CITY OF ALBUQUERQUE
PLANNING DEPARTMENT
DEVELOPMENT REVIEW BOARD

Project# 1006989

12DRB-70118 MAJOR - 2 YEAR EXTENSION OF SUBDIVISION
IMPROVEMENTS AGREEMENT (2YR SIA)

ADIL RIZVI agent for TIMOTHY & CHRISTINE HELMICK requests the referenced/above action for Lot 16-A, Block 16, Tract A, Unit B, **NORTH ALBUQUERQUE ACRES** zoned SU-2 FOR IP/ NC, located on the southwest corner of SAN PEDRO DR NE and ANAHEIM AVE NE containing approximately .9994 acre. (C-18)

UTILITY PLAN

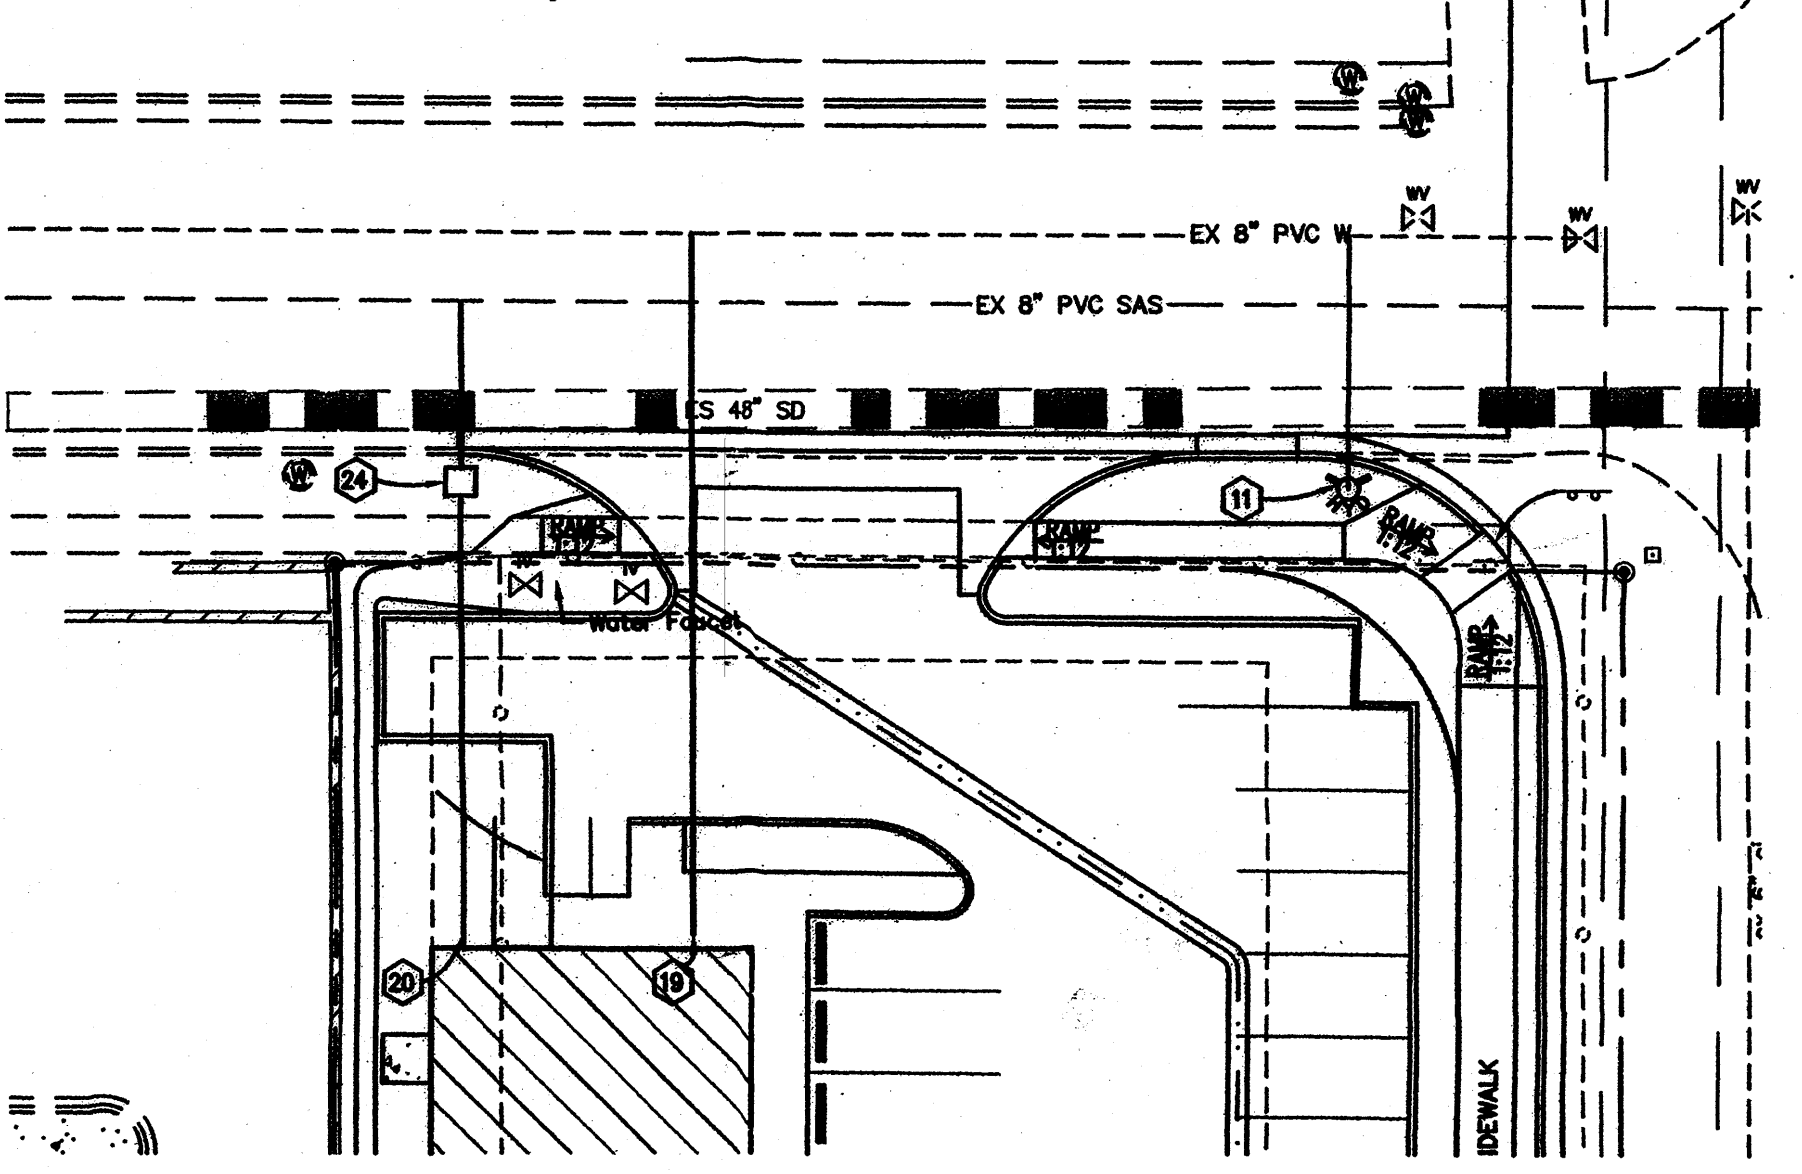
_There is an existing power pole located at SW corner of Anaheim and San Pedro. Is the pole located at a safe distance from the road? Would this pole be relocated as part of the construction of the San Pedro?

GRADING PLAN

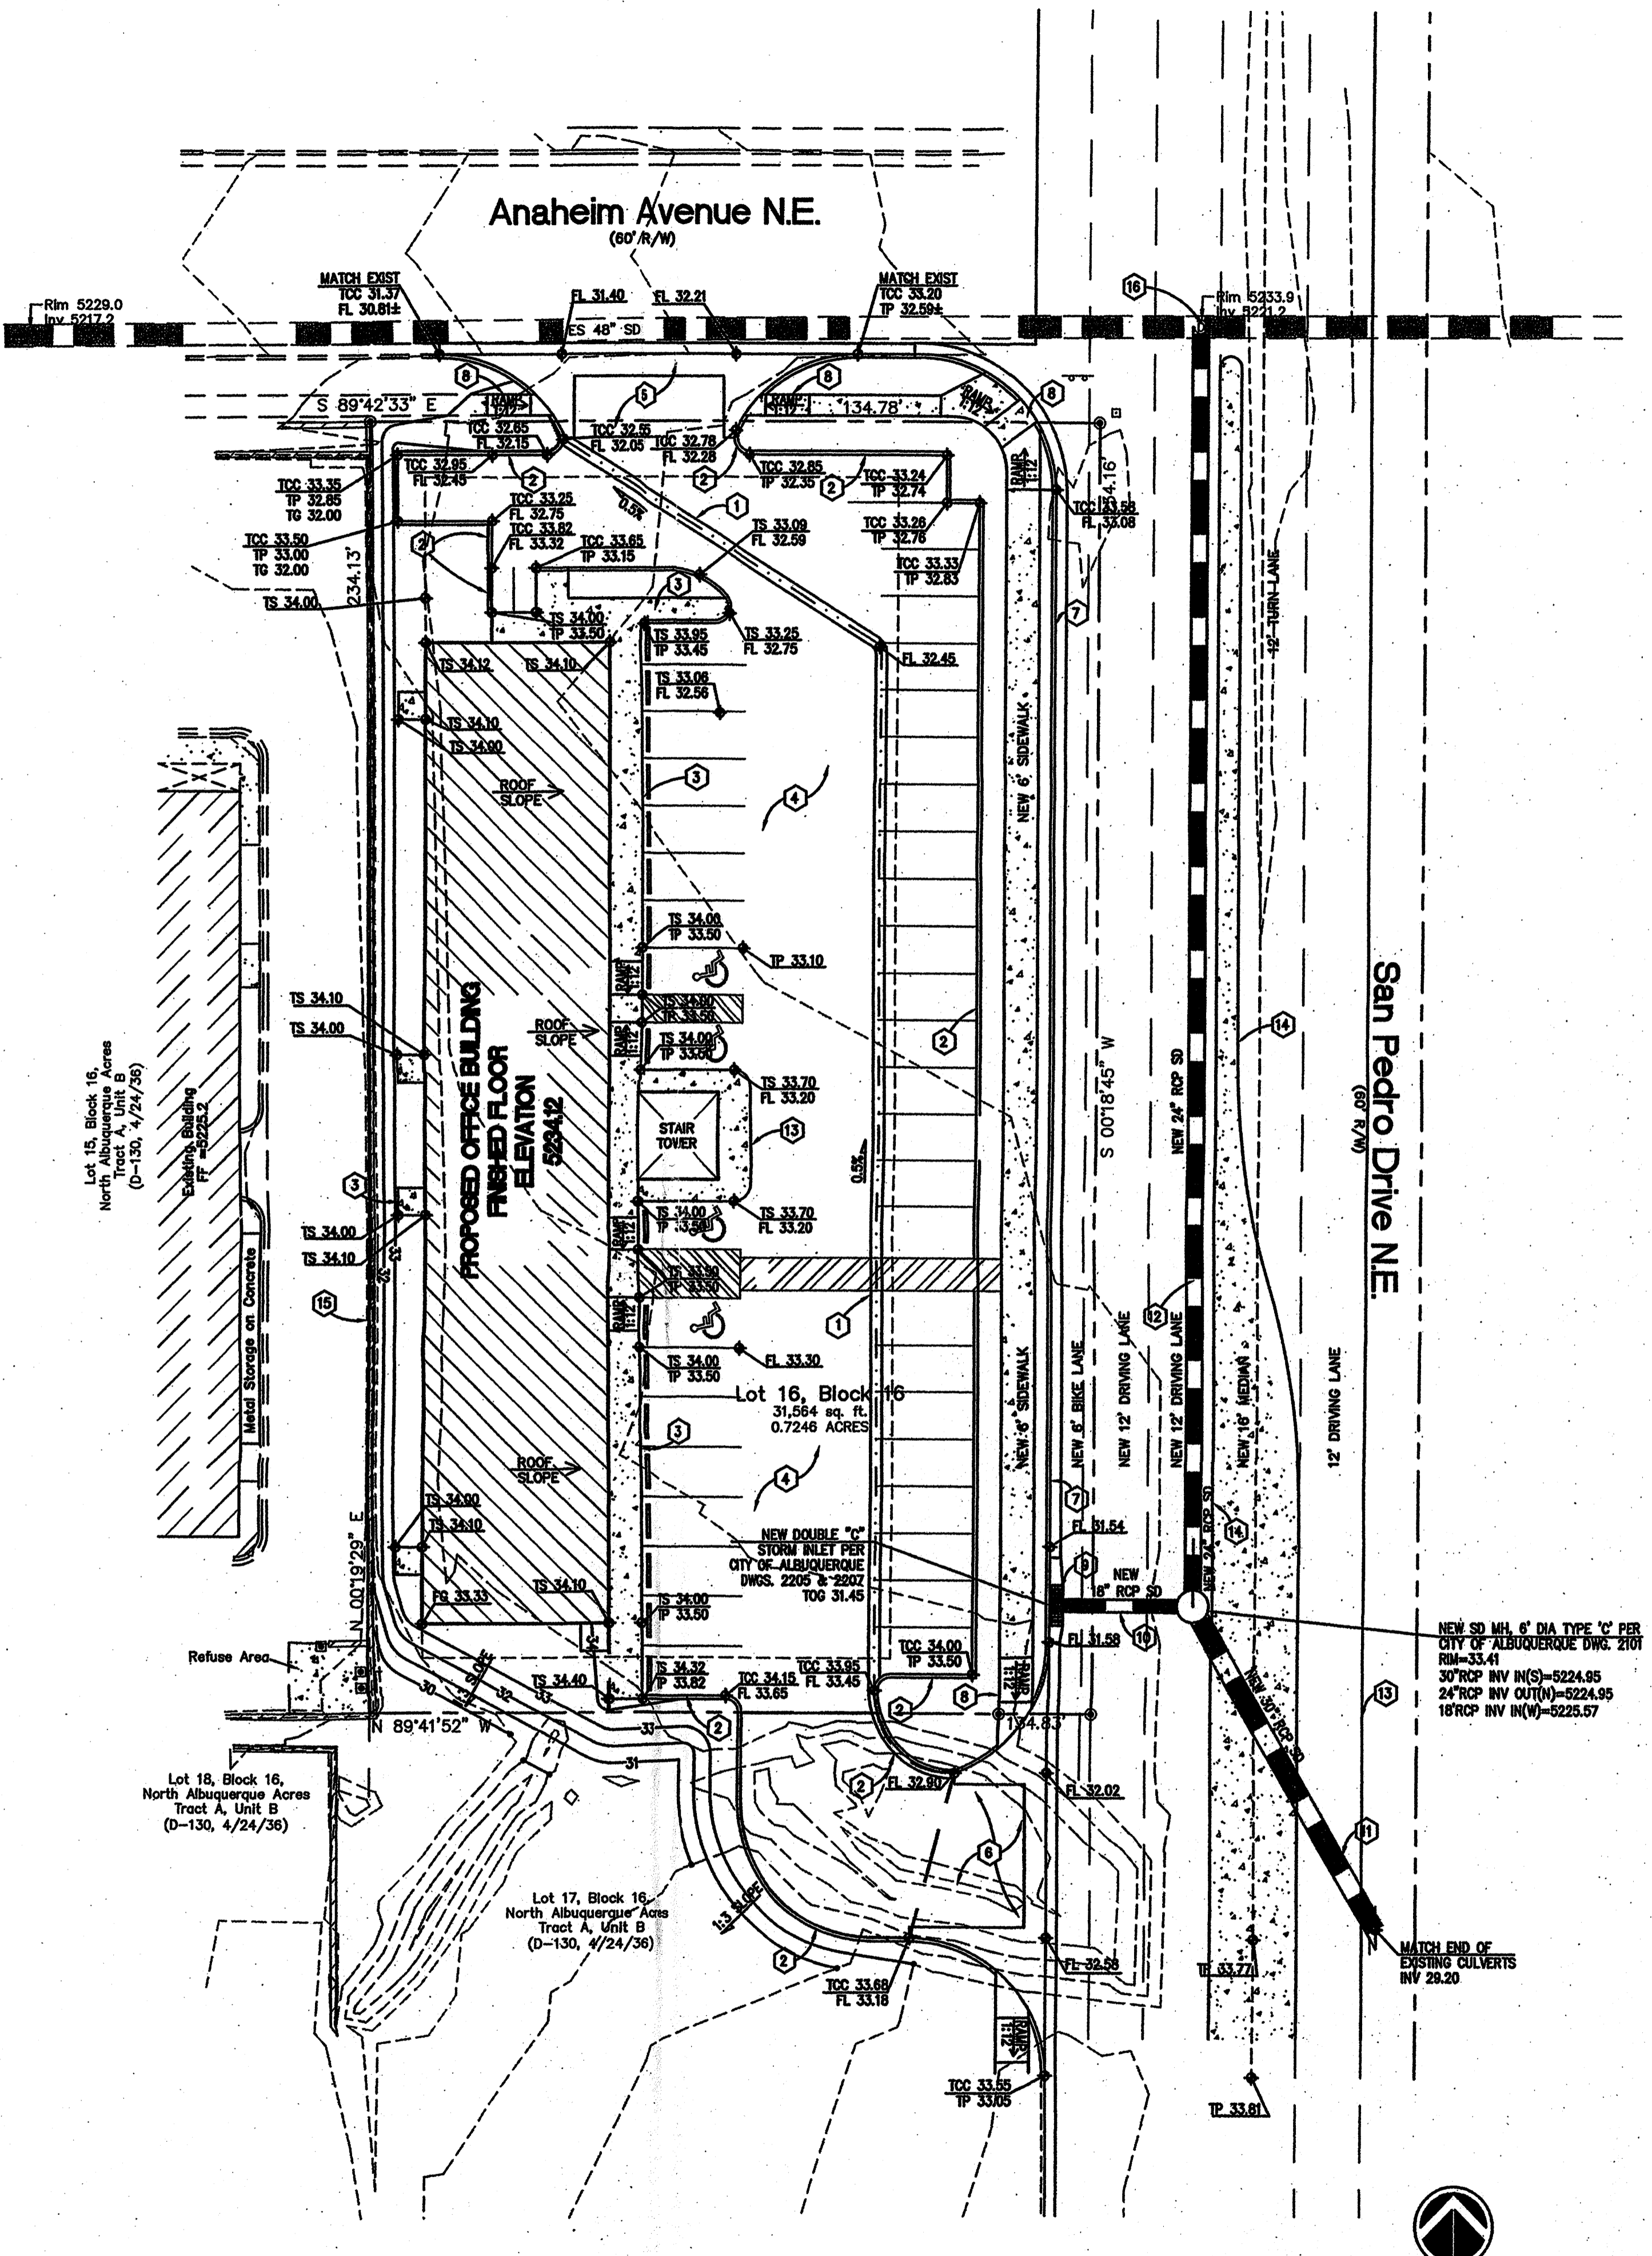
_The offsite runoff from the east (18.40 cfs) used to drain to this site. This runoff was supposed to be drain to the proposed storm drain pipe on San Pedro. Is this runoff currently ponding within the R/W?
